NORTH FALLS OFFSHORE WIND FARM DEVELOPMENT CONSENT ORDER

PINS REFERENCE EN010119

**THE PLA'S COMMENTS ON THE APPLICANT'S
RESPONSE TO THE EXA'S PROPOSED
SCHEDULE OF CHANGES TO THE DDCO AND
THE DEADLINE 7 DDCO**

Deep Water Route Cable Installation Areas (Future Dredging Depths) Plan

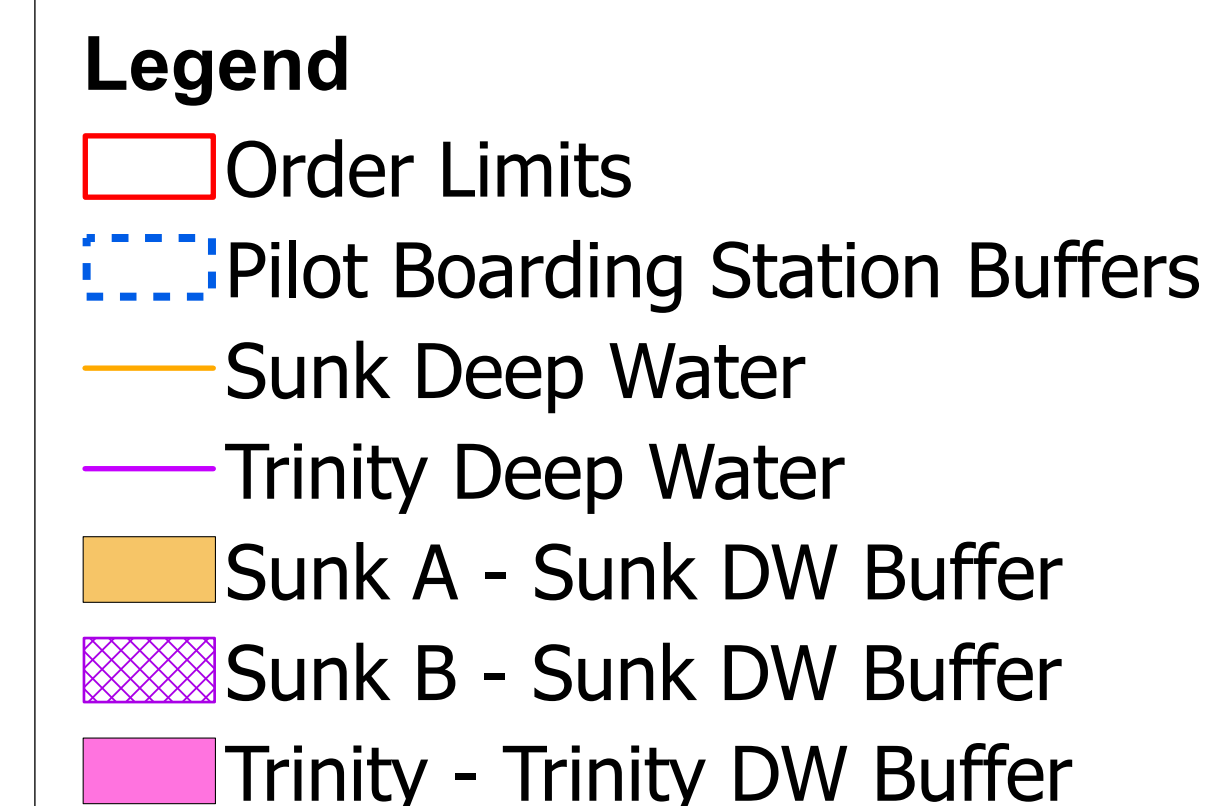
Schedule 12 – Documents to be certified				
Deep Water Route Cable Installation Areas (Future Dredging Depths) Plan (Rev 0) [REP4-043].	<p>PLA's amendments to Deep Water Route Plan [REP4-043] as described in PLA's [REP5-111] which includes a revised image showing additional areas to be included in green, namely:</p> <p>The majority of the green area will need to allow for dredging to -22m CD and the PLA could otherwise accept the 200m buffer to the south at -19m CD.</p>	The ExA considers this change to be reasonable.	<p>The Applicant updated the Deep Water Route Cable Installation Areas (Future Dredging Depths) Plan at Deadline 6 [REP6-055] to make the area around the sunk pilot diamond (shown coloured blue on that plan) protected from having its depth reduced to any less than -22m by Work No. 3 (see Requirement 2(3) of dDCO [REP6-005]).</p> <p>This, in effect, gives the same protection as the proposal by PLA, as the area around the sunk pilot diamond extends further than the areas proposed by PLA (even if not using the colour green).</p>	The updated plan REP6-055 is agreed by the PLA.
